From: James Smith
Sent: 20 October 2014 11:01
To: [REDACTED]
Subject: 29 Sea Lane Gardens, Ferring (our ref: FG/125/14/CLP)

I am currently reviewing your application for a Certificate of Lawful Development at 29 Sea Lane Gardens. I would just like to query the description. Having looked at the original plans for the dwelling it would appear that the proposed is an extension to the rear rather than to the side. If it is regarded as a side extension it would not qualify as Permitted Development as it would be attached to the existing rear extension and the combined width of the two features would exceed half the width of the original dwelling (see page 25 of the Technical Guidance for Permitted Development for Householders

Drawing Number:
1068 / 03

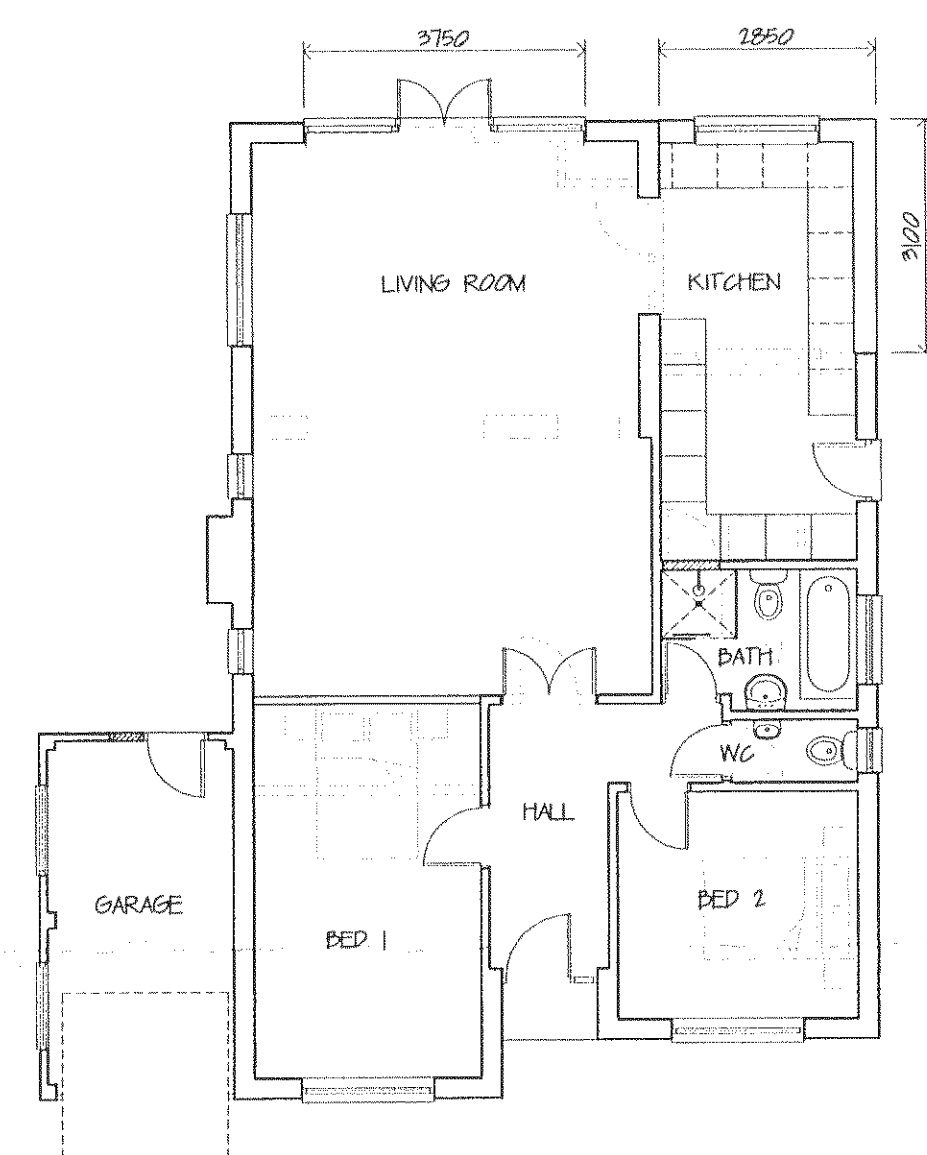
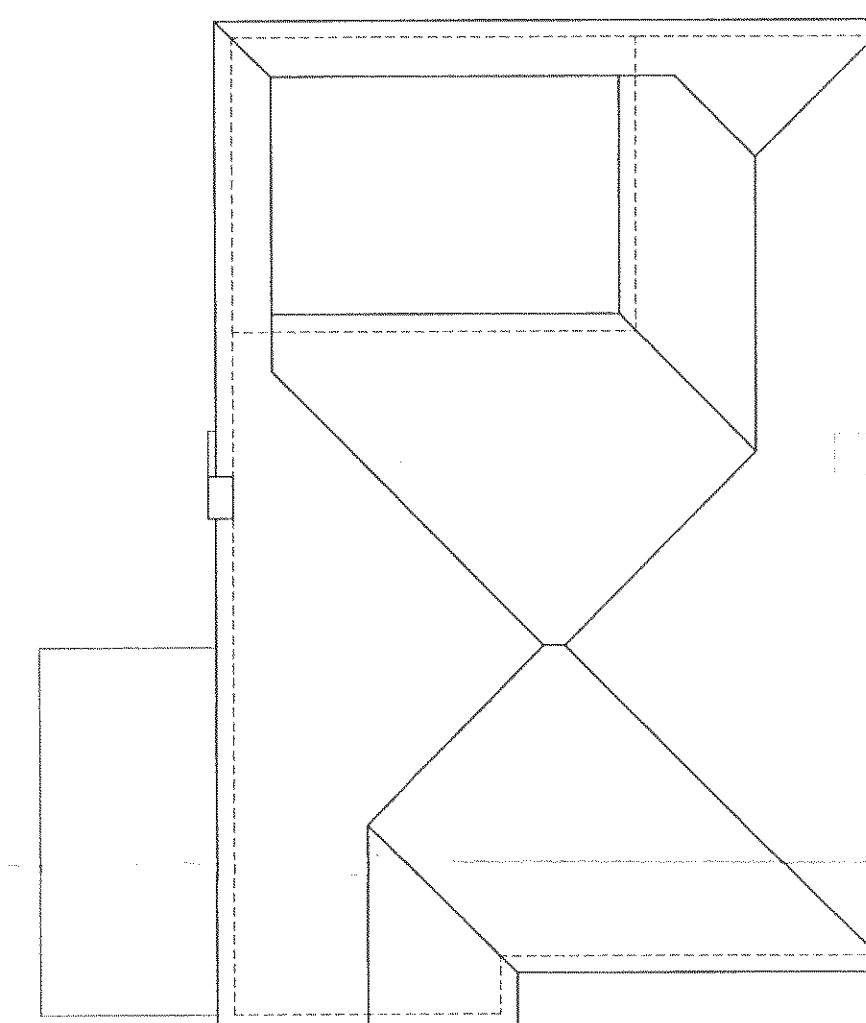
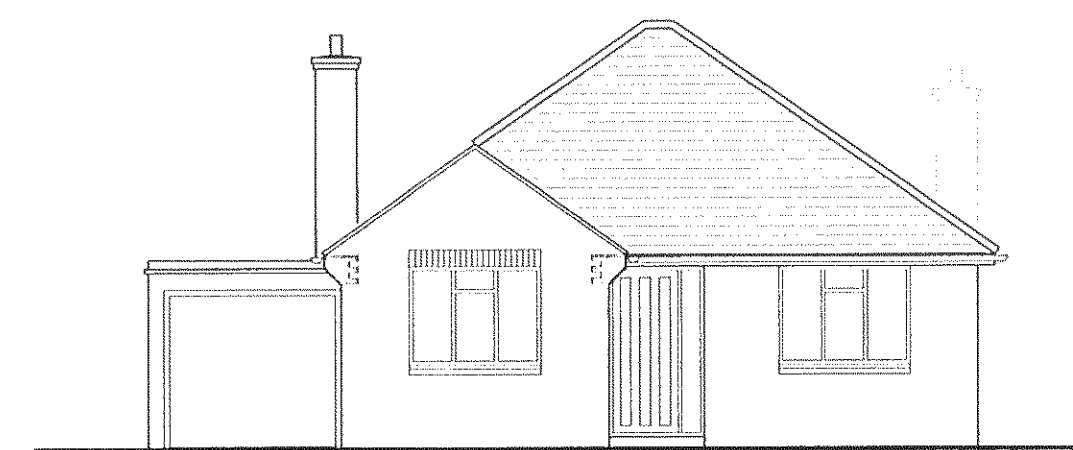
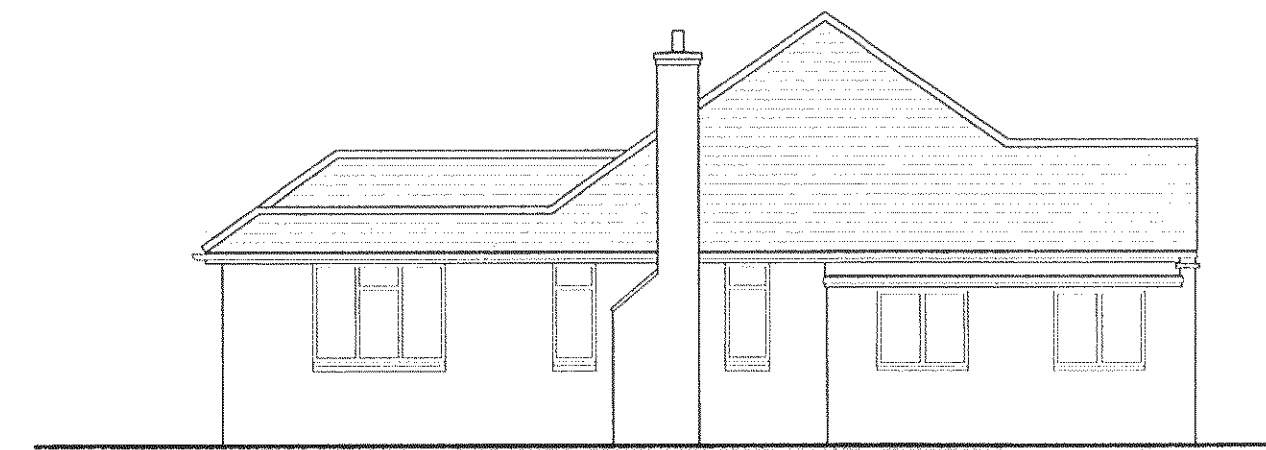
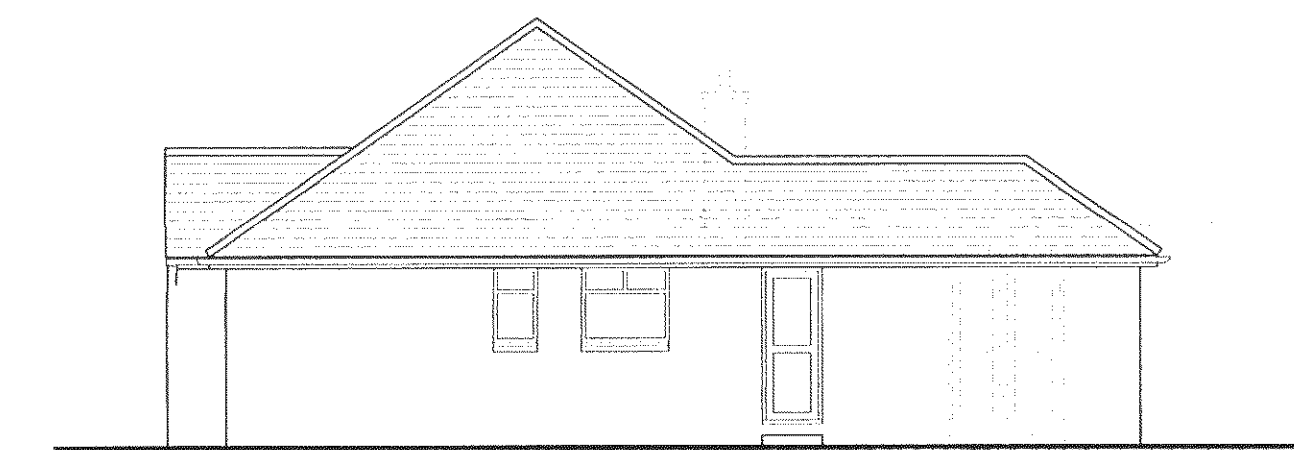
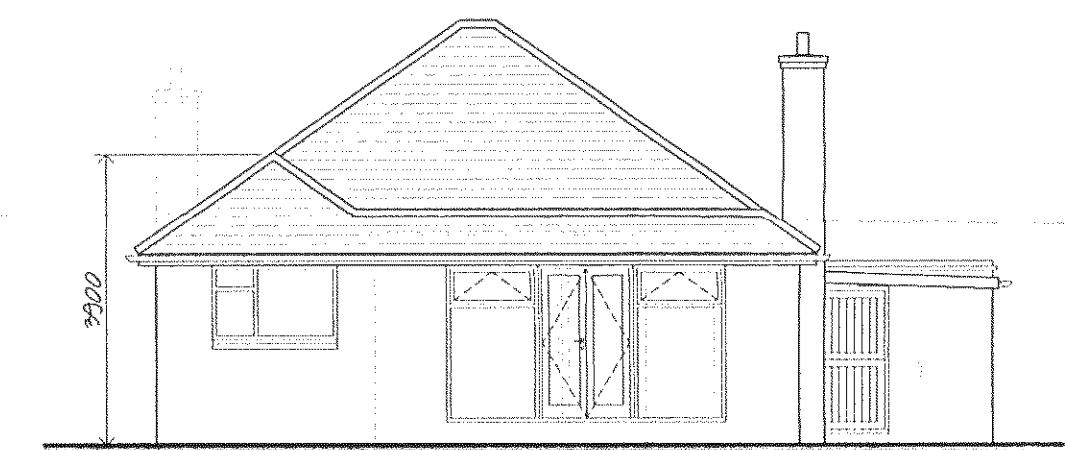
Could you please confirm that you agree that the description should be altered to read as an extension to the rear rather than the side?

I confirm that I agree with the amended description.
